Arun District Council
Arun Civic Centre
Maltravers Road
Littlehampton
West Sussex BN17 5LF
Planning & Building Control General Enquiries
Tel: (01903) 737756 Fax: (01903) 730442
Dx: 57406 Littlehampton
Minicom: 01903 732765
e-mail: planning@arun.gov.uk
website: www.arun.gov.uk/planning

Application No: LU/149/20/PL
Site Address: Littlehampton Wave Sea Road Littlehampton BN16 2NA
Description of works: Installation of a 4m high timber sculpture shaped in the form of 3 No. waves, fixed to a concrete base. This application is not CIL Liable (Zero Rated) as 'all other development'.

Thank you for your internet representation made on 9th July 2020 which has been recorded as an objection with the comments as follows:

Elevation of Wave Sculpture

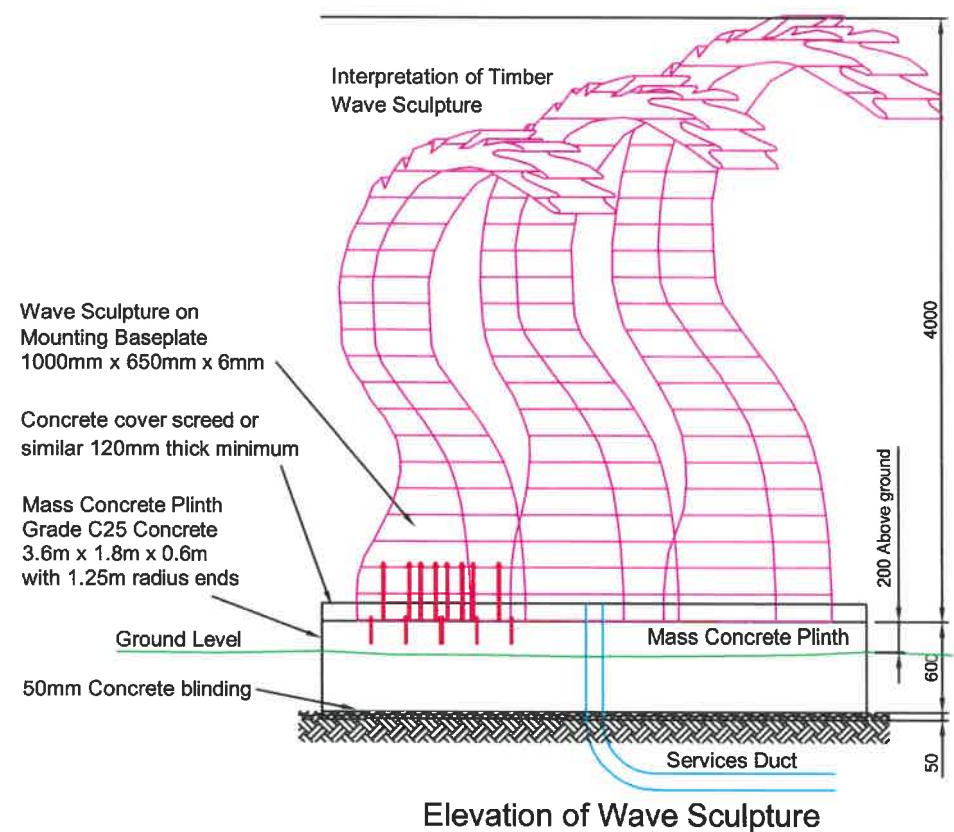
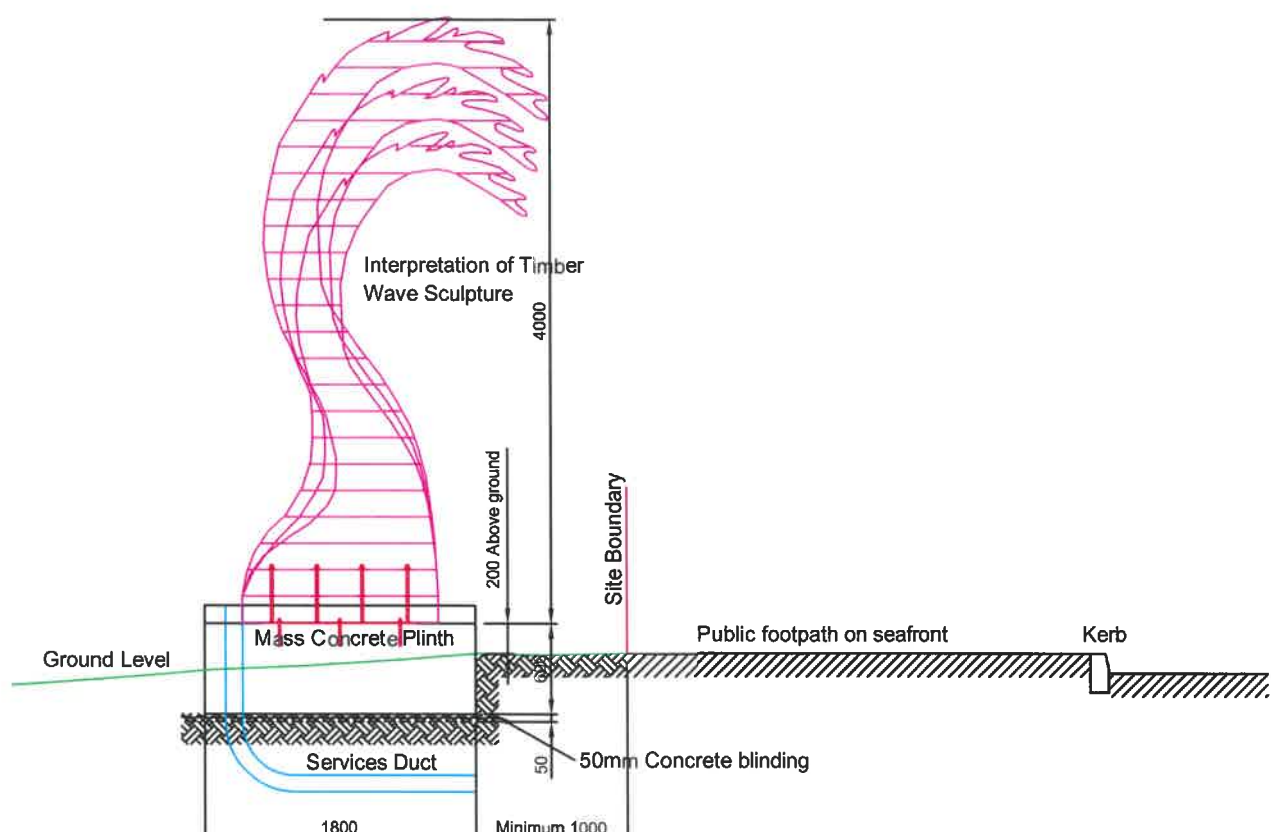
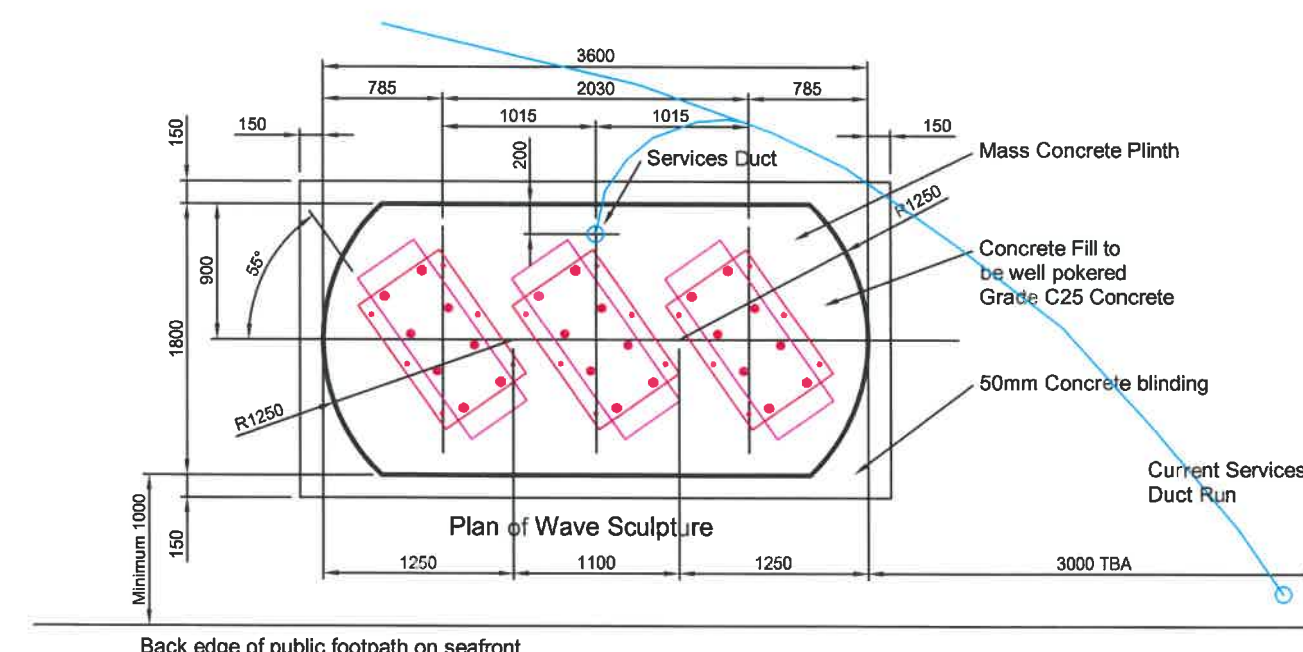
The structure proposed, being made of wood, would degrade so close to the sea and require significant ongoing maintenance over time. The cost of this would fall to the ratepayers. Also a wooden structure is not as robust against vandalism as a metal structure would be.

The proposed structure is not sympathetic to the surroundings. It looks like 3 " £" signs rather than the waves it was supposed to highlight to passers by. I propose that a selection of designs be put out to ratepayers for consideration.
